RE: SSD-23330227 UPGRADES TO JOHN PALMER PUBLIC SCHOOL - SUBMISSION

This letter has been prepared on behalf of ISPT Limited (ISPT) as a formal submission to the exhibition of the Environmental Impact Statement and supporting documents for the “Upgrade to John Palmer Public School – SSD-23330227 (SSD).

Figure 3.6: Service vehicle access

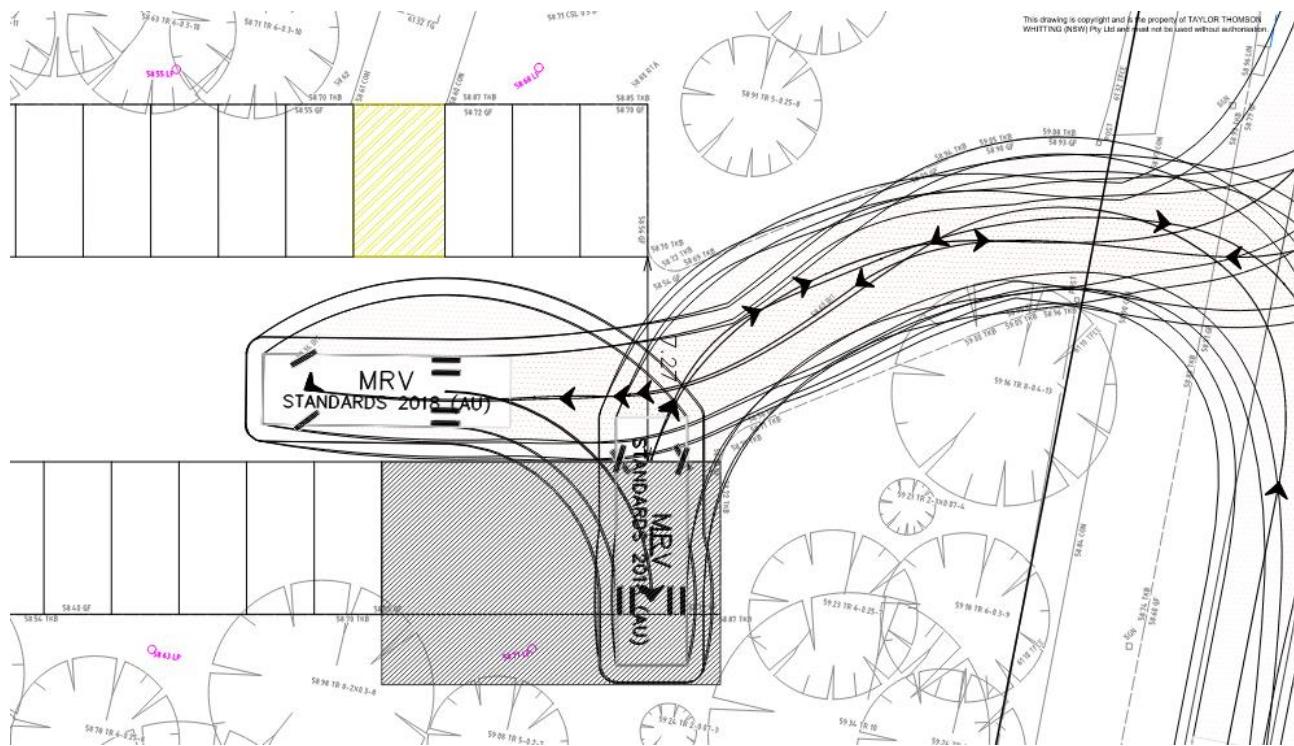
The proposal indicates that no additional car parking is proposed and that the design will result in the removal of 2 at-grade car parking spaces for staff. That is the existing at-grade car parking area will be reduced from 37 spaces to 35 spaces. This is to accommodate waste collection and a loading zone. It is unknown how waste contractors service the site during current operations.

Detailed Car Park Layouts

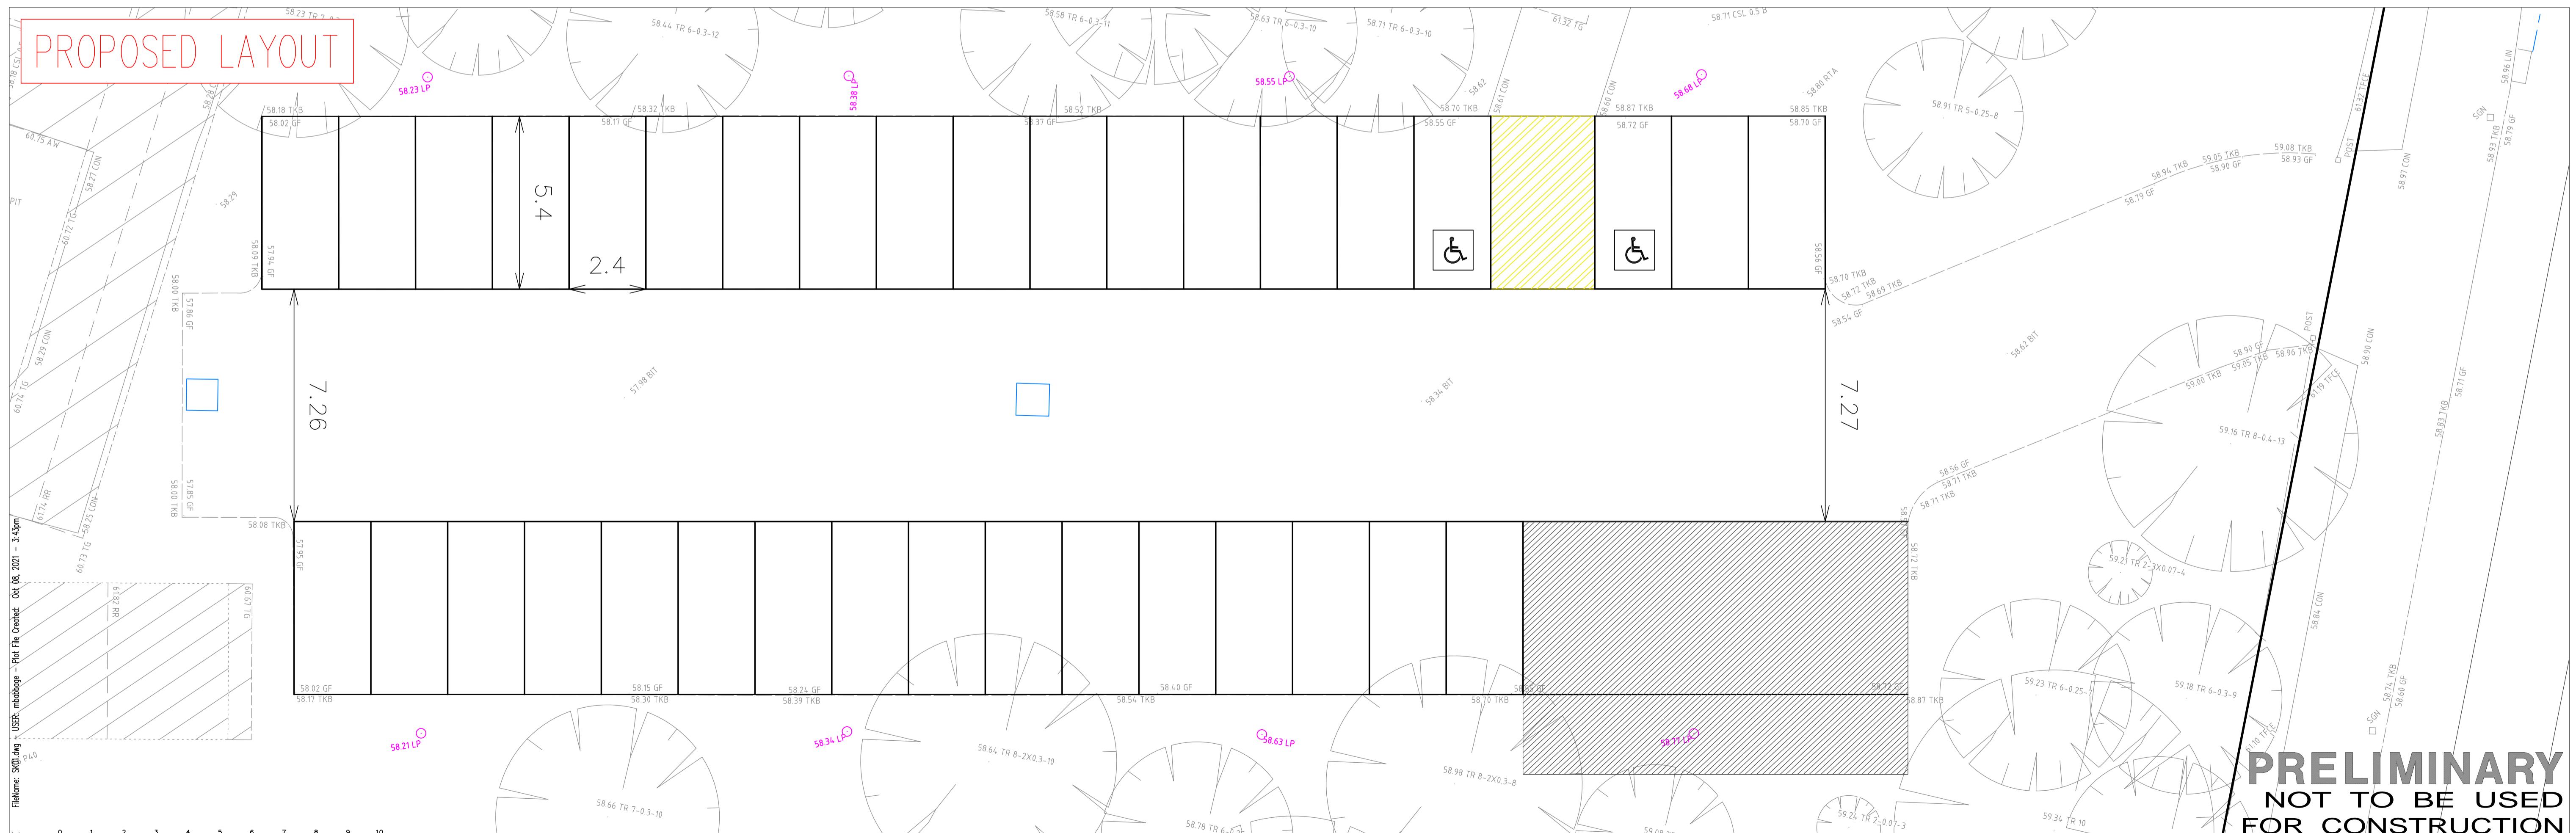
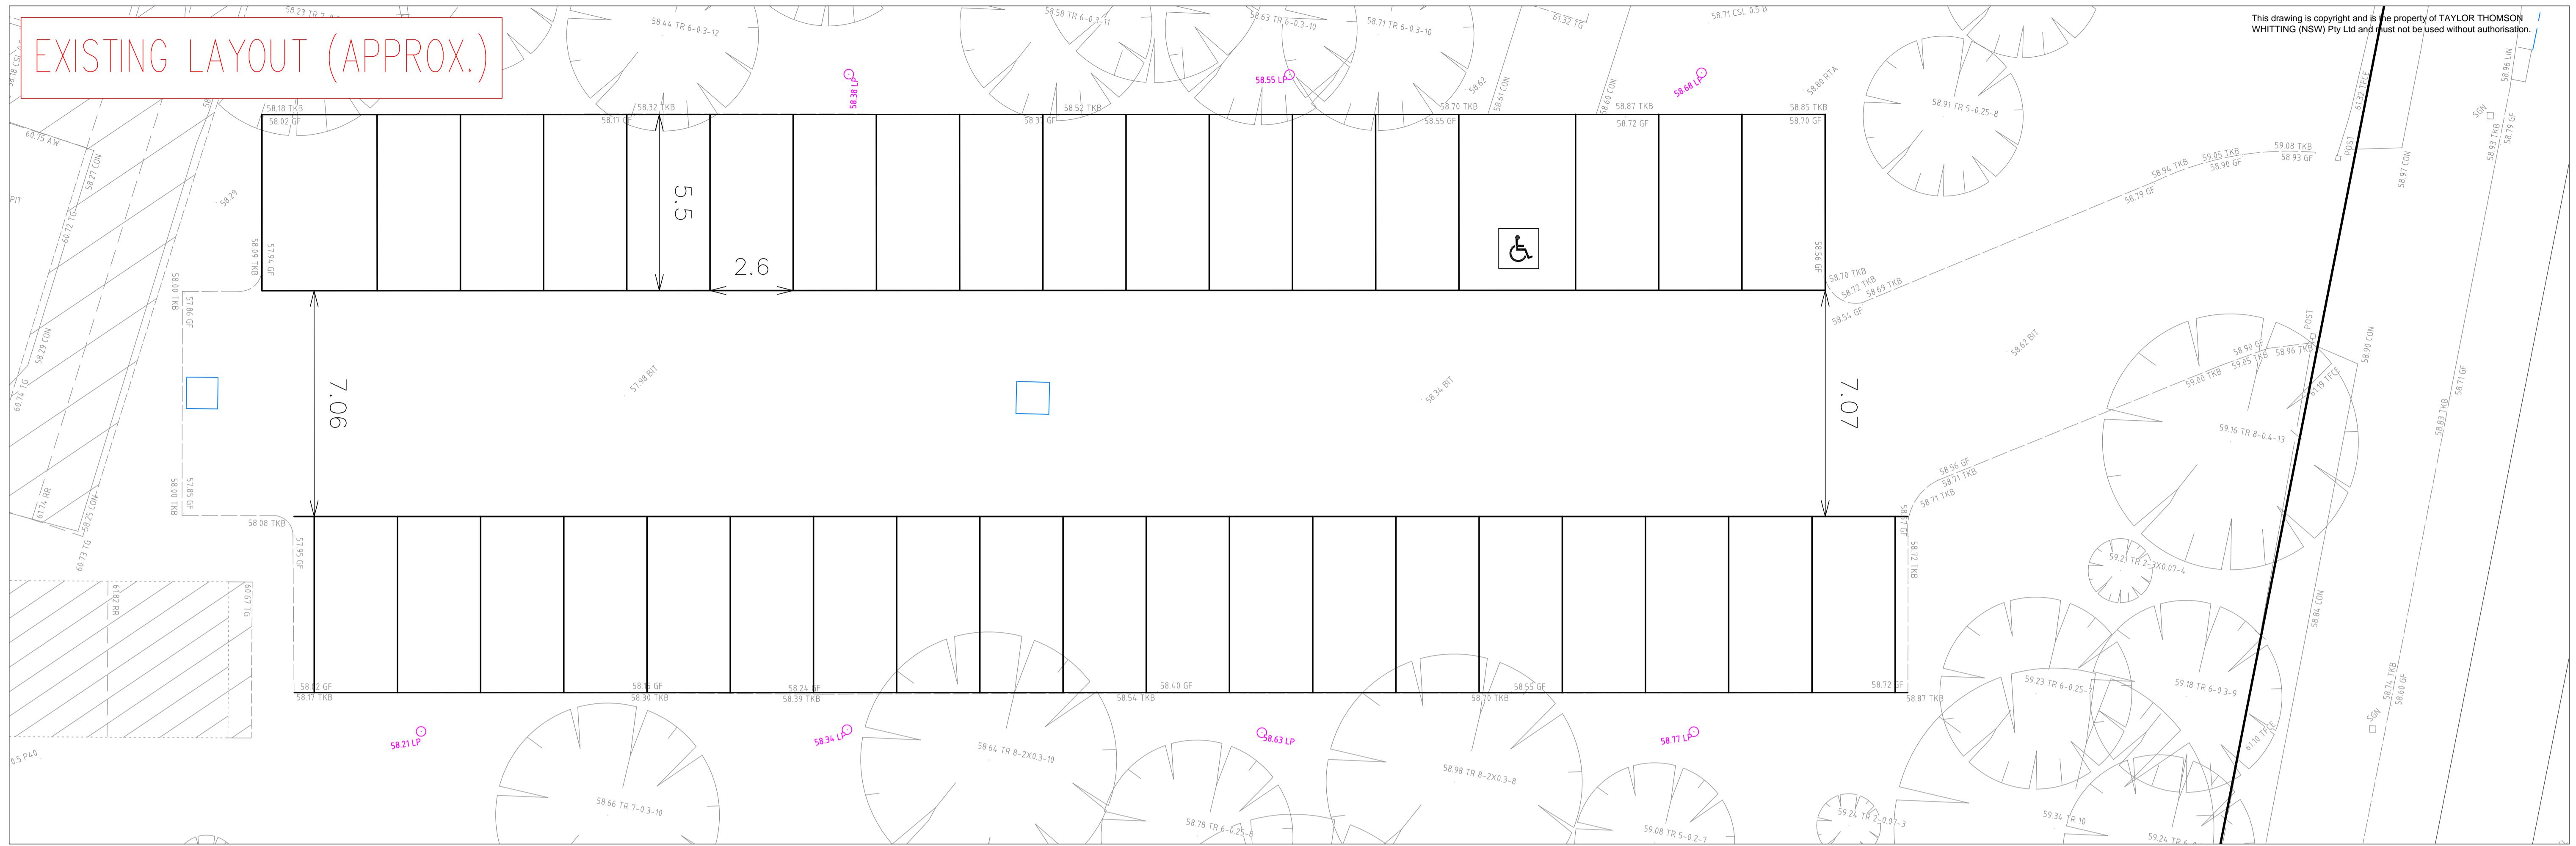
Parking on-site for staff of the school is at capacity.

It is not clear to IPST why the proposal does not accommodate all car parking attributed to staff of the school on their site as is required for all other forms of development where there is limited access to public transport networks.

ISPT wish to advise that this proposal must provide on-site car parking in accordance with the DCP requirements for staff of the school as a mechanism to reduce pressure for car parking associated with the school “spilling” into The Ponds shopping centre car parking. The proponent seeks a variation of the DCP and should demonstrate there is no adverse impact from the variation. Also, it is commonplace for ISPT to have to implement Green Travel Plans for tenants of their site development where car-pooling is required for sites which are remote from public transport and mechanisms to promote usage of public transport where a site is located in close proximity to public transport nodes with incentives inclusive of travel passes being issued for free to staff members. It is commonplace for the Green Travel Plan to also have a review mechanism to check for compliance and demonstrate tenants’ enforcement of the Green Travel Plan as a mechanism to force a change of behaviour away from reliance on private vehicles.
